**KIRKLEES METROPOLITAN COUNCIL
INVESTMENT & REGENERATION SERVICE**

DELEGATED DECISION TO DETERMINE PLANNING APPLICATIONS

Reference No: 2021/62/90172/W
Site Address: 11, Olney Street, Slaithwaite, Huddersfield, HD7 5EG
Description: Erection of two storey extension to side
Recommending Officer: Ellie Worth

DECISION – Conditional Full Permission

Dwg ref: 11OS-P2/P03 a : Scale 1:100 @ A3 : December 2020 : As Proposed Elevations

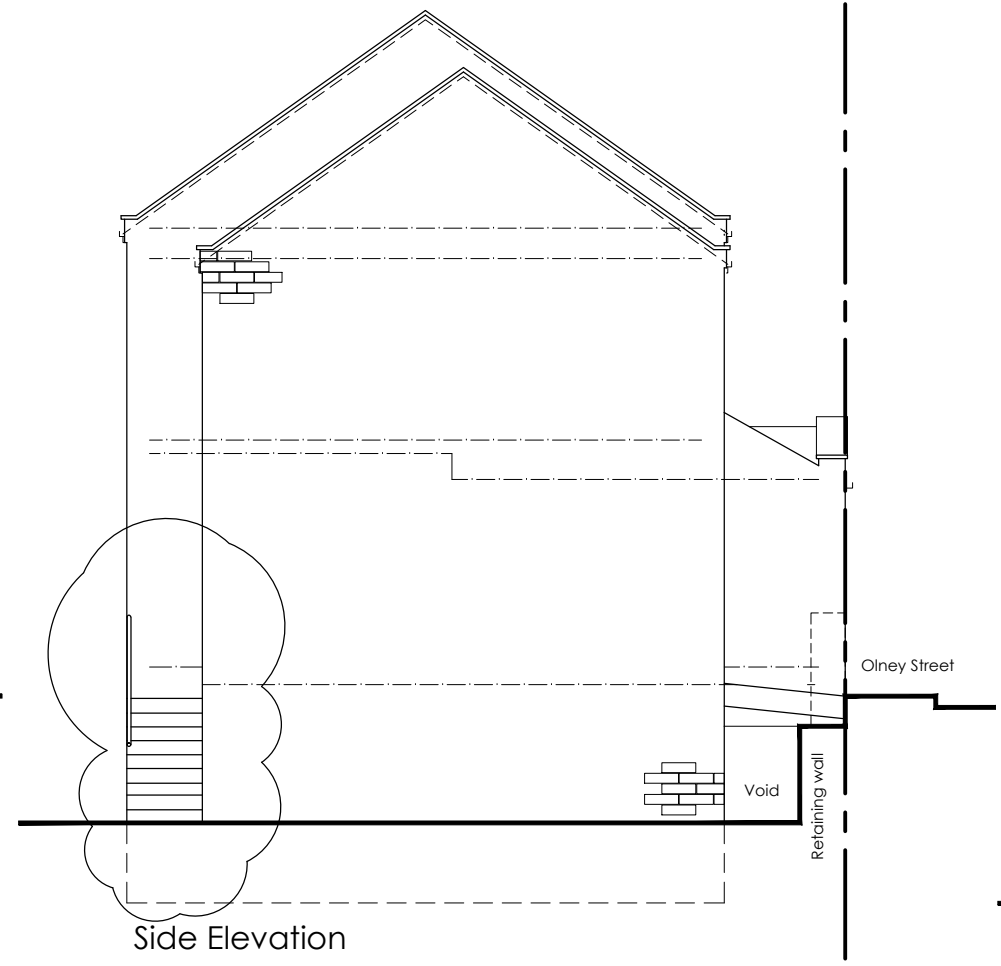
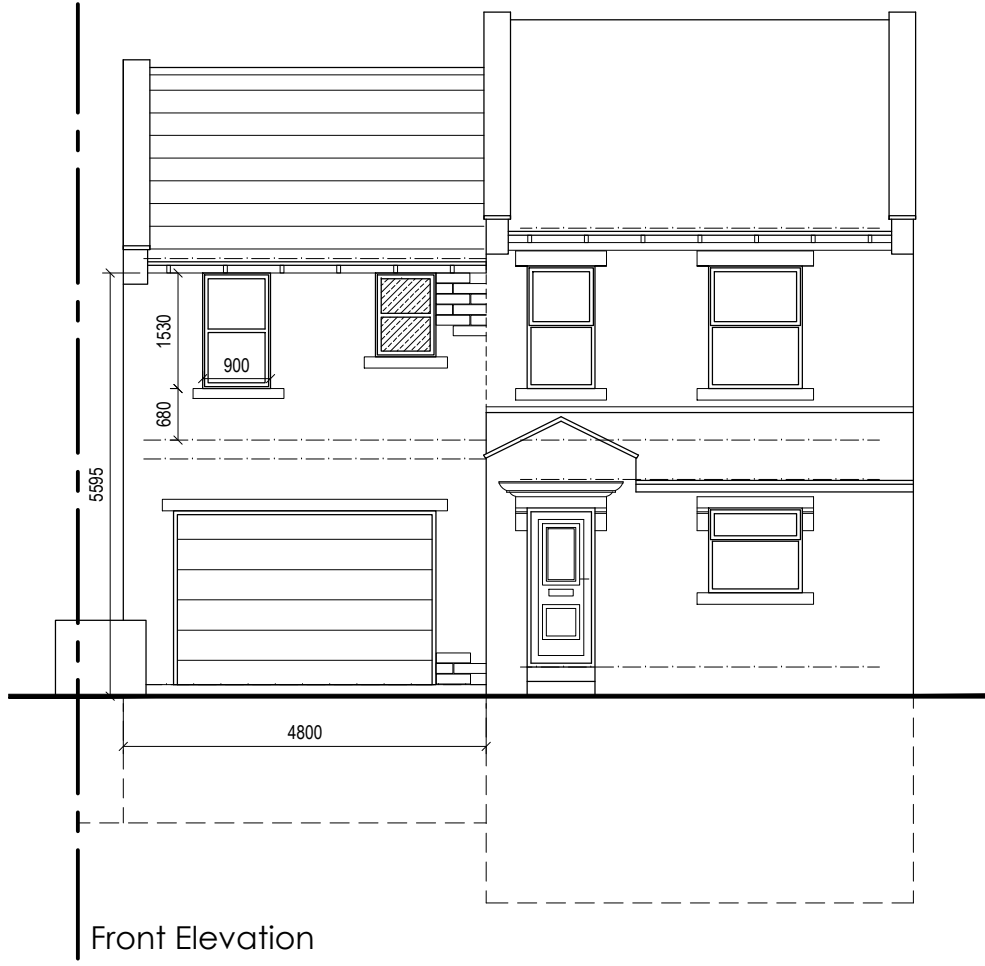
Discussions have been held regarding the roof tiles, whereby the agent has confirmed that a natural slate will be used and therefore a condition should be attached to the decision notice accordingly. Updated floor and elevation plans have also been sought to show the rear staircase. These were received on the 26th and 30th March 2021.

Given that the amendments sought were to demonstrate the rear external staircase on all proposed floor plans and elevations, officers did not consider it necessary to re-advertise the scheme.

The proposed fenestration would also be of a similar appearance to those that exist on the host property and will benefit from stone heads and cills. To the rear, a Juliette balcony is proposed, however, any impact from this more modern style of fenestration would not be unduly incongruous with it being sensitively sited within a secondary rear elevation of the property, away from the principal streetscene.

A large garage door will also be inserted into the front elevation; although this does not follow the original design of the dwelling, it is a commonplace feature of dwellings within built up areas and therefore no concern is raised regarding this element of the development.

The submitted plans do not show any new openings to be inserted into the side elevation of the two storey extension, which will preserve these neighbour's amenity. Nonetheless, future permitted development rights for ground floor openings within this elevation will be removed, in order to restrict any overlooking. Future first floor side openings would also need to be obscurely glazed in order to comply with the GPDO.

- The rear staircase is an eyesore
Comment: The design of the extension has been thoroughly assessed within section 2 of the report above. The details of the scheme, including the external staircase to the rear, are considered to be of suitable design quality to approve.

The design of the proposal has been considered acceptable from a visual perspective, as the extension would follow the simple form of the original property and would be constructed from stone to match. The agent has also confirmed that the roof will be finished in natural slate to match the host property and therefore a condition will be attached to the decision notice accordingly.

4. Notwithstanding the details set out within the application form, the roofing materials of the two storey side extension hereby approved shall be natural blue slate to match those used in the construction of the existing building.

5. Notwithstanding the provisions of the Town and Country Planning (General Permitted Development) (England) Order 2015 as amended (or any Order revoking or re-enacting that Order) no windows or any other openings (apart from any expressly allowed by this permission) shall be created in the ground floor North Eastern facing side elevation of the attached garage hereby approved.
